**RESPONSE TO THE DEPARTMENT'S REQUEST FOR FURTHER INFORMATION  
ELIZABETH DRIVE SUBDIVISION (SSD 8859)**

Ae Design Partnership has prepared this letter on behalf of Elizabeth Drive Pty Ltd (**"the Applicant"**) in response to the Department's Request for Request for Additional Information letter dated 23 November 2020 (**Attachment 1**) in relation to the State Significant Development 8859 (**"SSD 8859"**) application on the property legally identified as Lot 2 Section 4 DP 2954, otherwise known as No. 1111-1116 Elizabeth Drive, Cecil Park (**"the site"**).

PROJECT
 1111-1141 ELIZABETH DRIVE,
 CECIL PARK

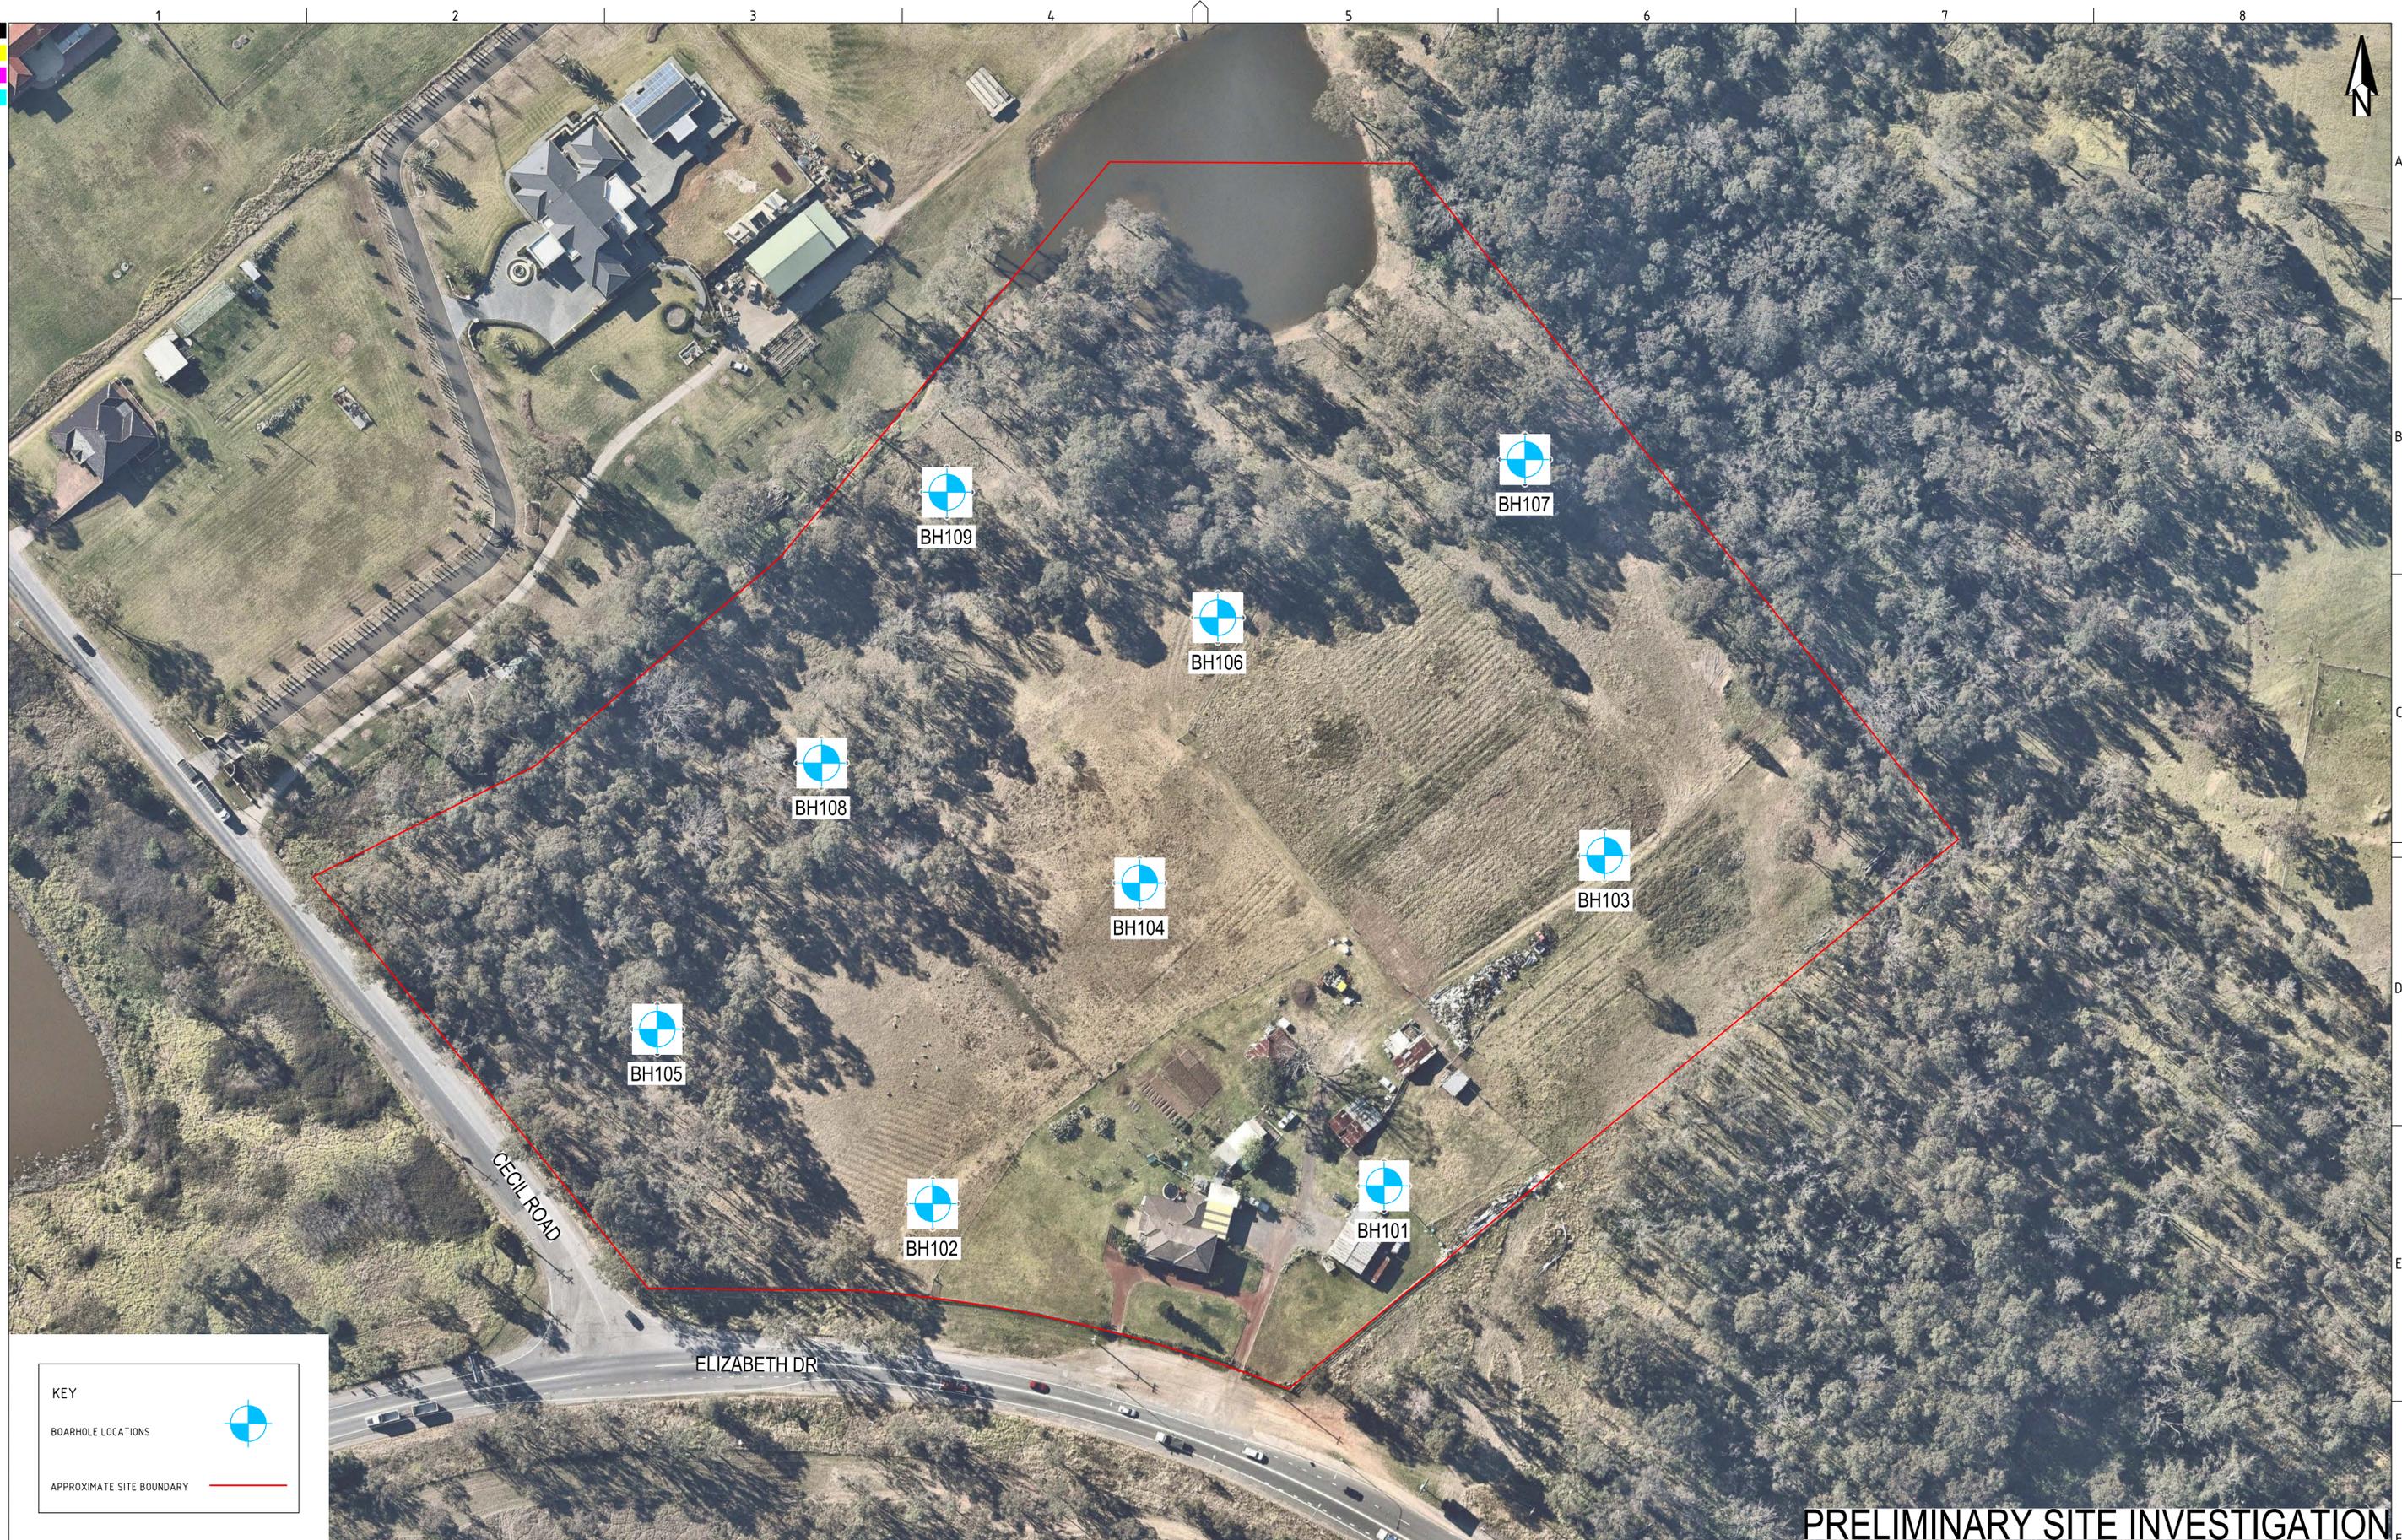
**Issue Raised:** *The Department considers that further consideration needs to be given to Jemena's submission dated 26 March 2019 and reiterated in its submission of 12 November 2020, particularly relating to future development of the site being located within 76 metres from the boundary of its pipeline easements.*

*The Department suggests consideration be given to reconfiguring some of the lots so that they don't partially sit within the 76 metre setback. This includes:*

- a) *realigning lot 5 and lot 6 to ensure lot 5 is wholly outside of the setback*
- b) *realign lot 11, potentially splitting the lot into two allotments*

**Response:** The concept subdivision plan has been amended in the Revised Drawing Package at **Attachment 2** as follows:

- a) re-alignment of Lot 5 eastern common boundary with Lot 6:
  - i) reduction of **1,034 SQM** to Lot 5 so that it is wholly outside the 76 metre buffer to Jemena's Gas Pipeline easement
  - ii) increase of **379 SQM** to Lot 6
- b) re-alignment of Lot 11 south-eastern common boundary with Lot 10:
  - i) reduction of **783 SQM** to Lot 11
  - ii) increase of **1,032 SQM** to Lot 10
